18 April 2013

Our Ref: LED 12/87

**Response to Submissions – Modification of Project Approval (08-0200 Mod 1) – Central Open Space,  
Cobaki and Modification of Concept Plan Approval (06 0316 Mod 1) – Cobaki Estate**

FIGURE 33A  
PREPARED: BW  
DATE: 05 April 2013  
FILE: 97038\_EA\_Base.dwg

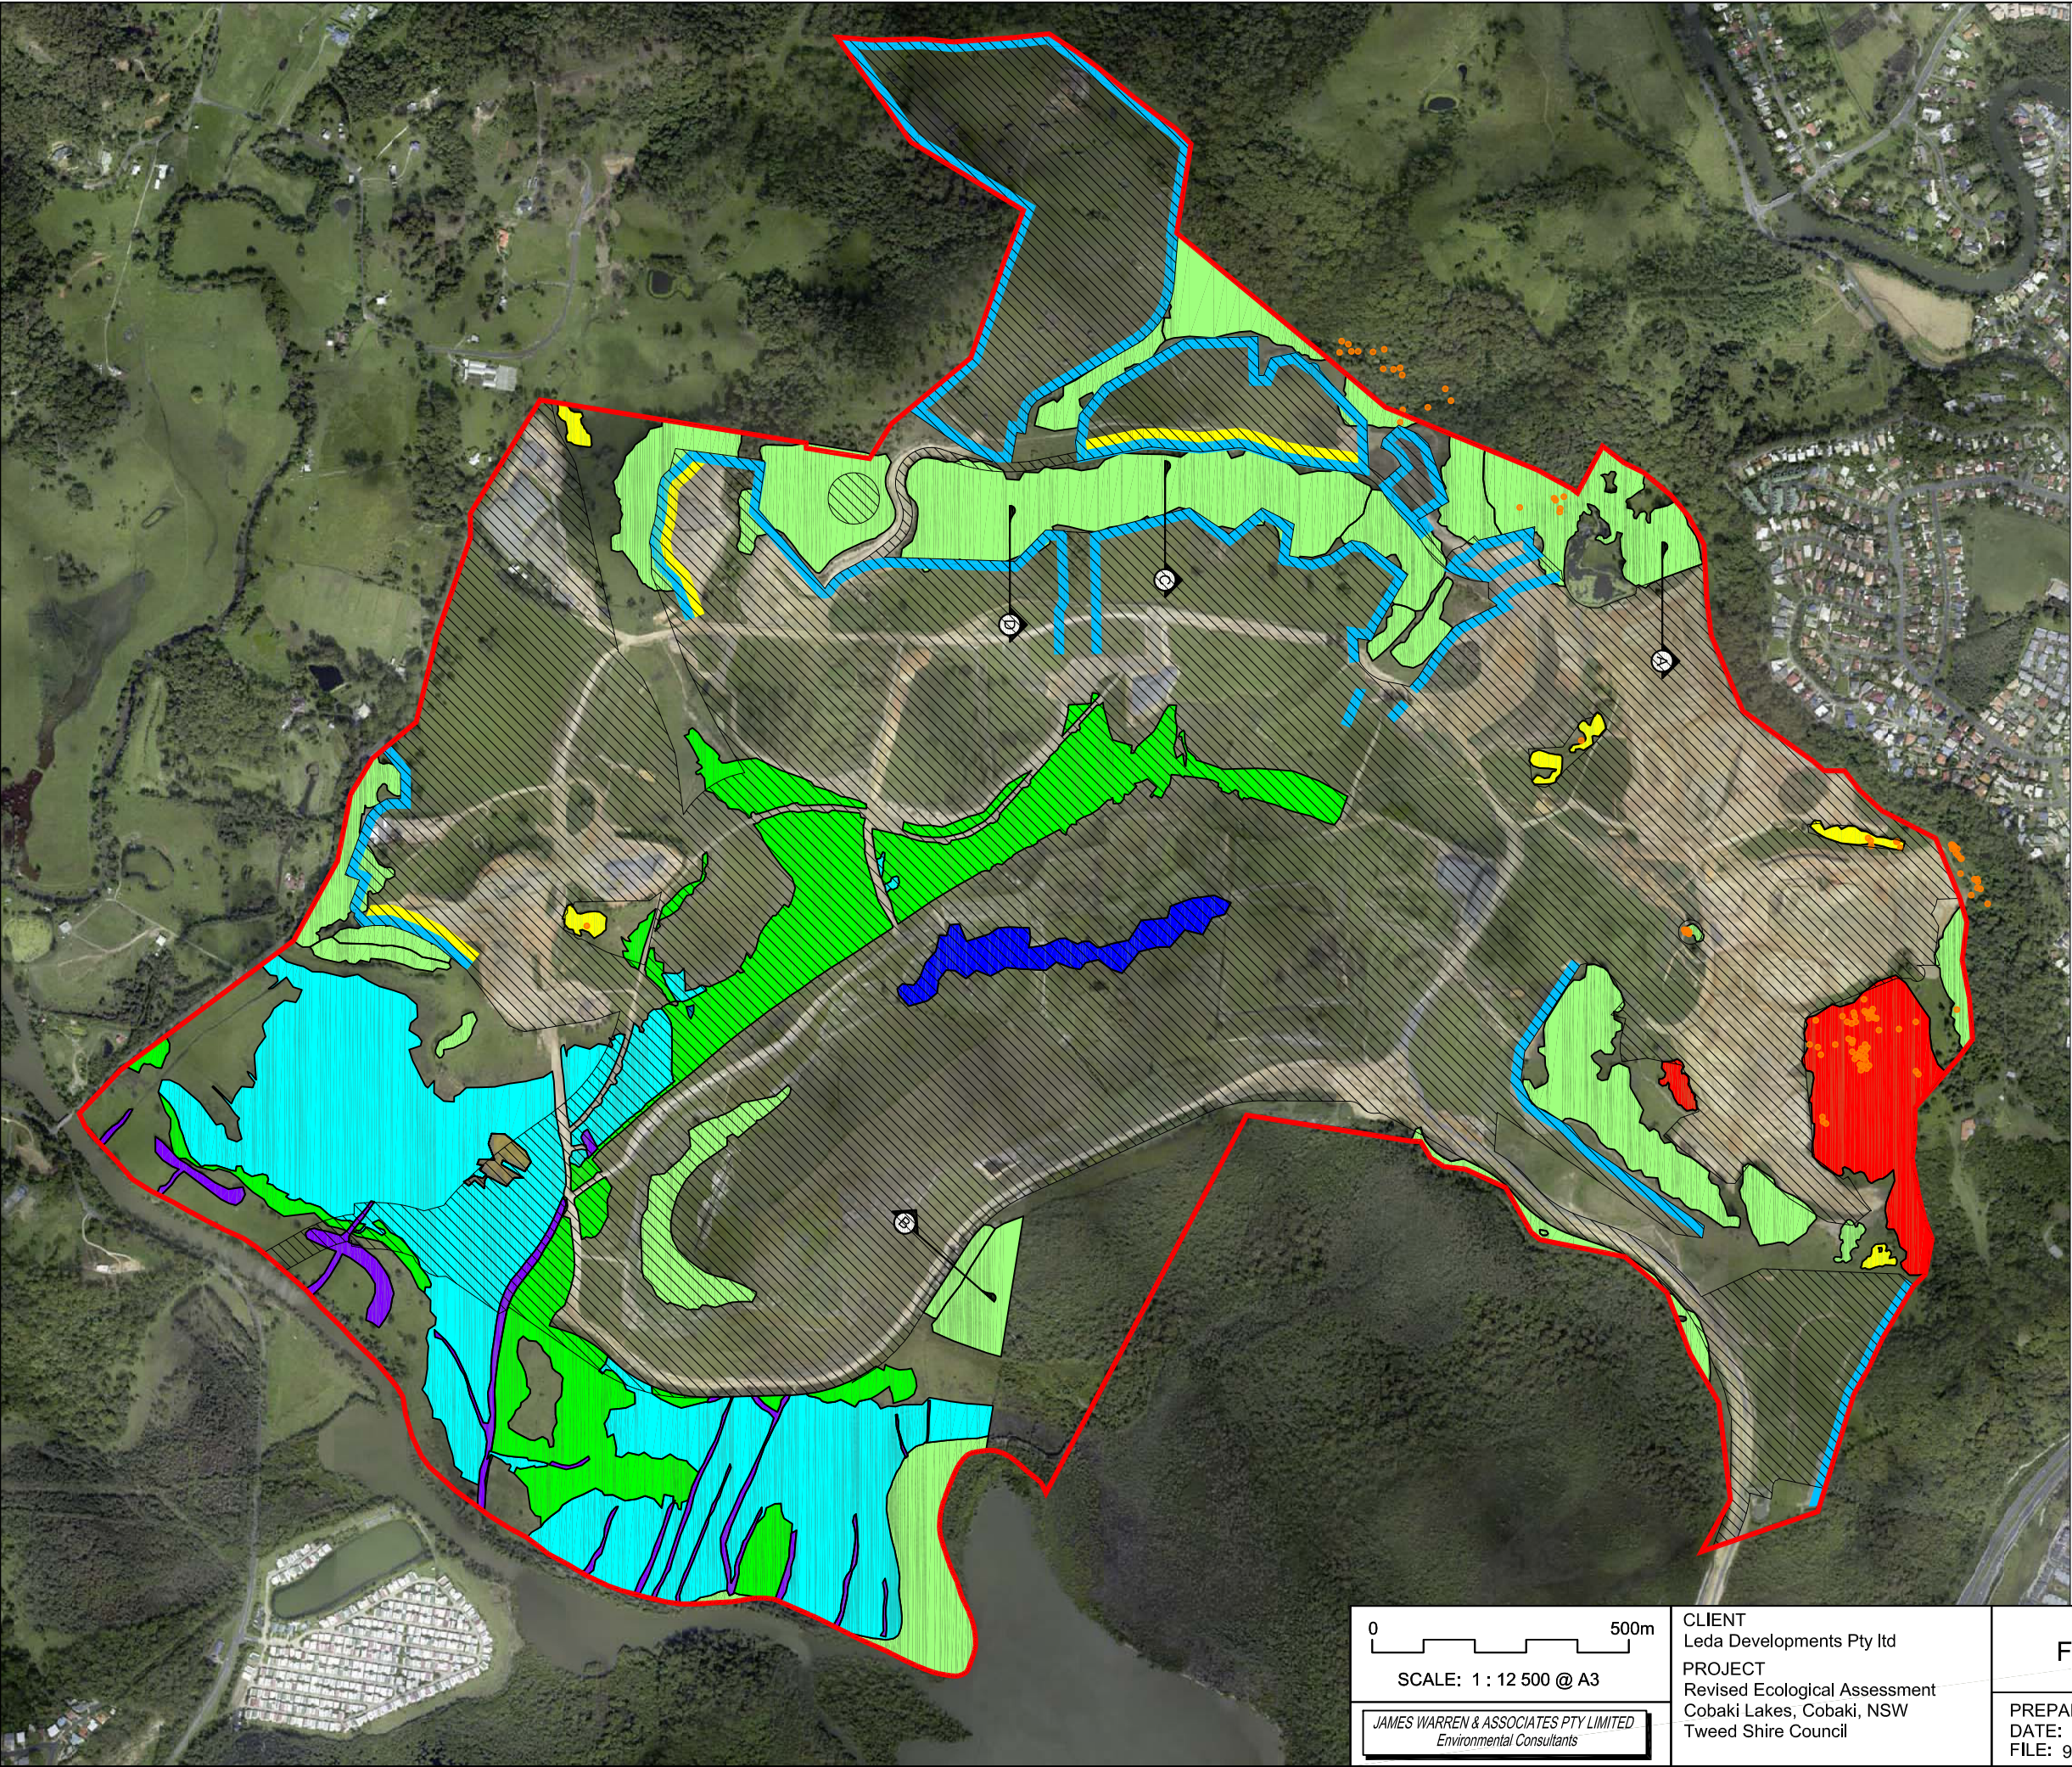
TABLE 1 – ECOLOGICAL ASSESSMENT	
ISSUE	RESPONSE
Explain changes to the areas shown as open space and environmental protection areas. These changes affect the approved Open Space Network Plan and other approved plans. These should be submitted to the department for approval.	Amendments have been made to the report to reflect the original Concept Plan domains.
In Fig 26 the extent of Freshwater Wetland (Degraded) is shown through the central open space area and saltmarsh areas in green, however, in Fig 33A, this extent is shown as a green grid. This is not shown on the plan. Please review the legend/mapping of this plan.	Plan amended.
Fig 33A does not show Lowland Rainforest to the east of Precinct 4 or the proposed U-shaped Swamp Sclerophyll offset in the north of the central open space area. Please amend this plan to be consistent with the proposed offset areas.	Figure 33A does not show offsets. It only provides the current extent of EECs. No change has been made.
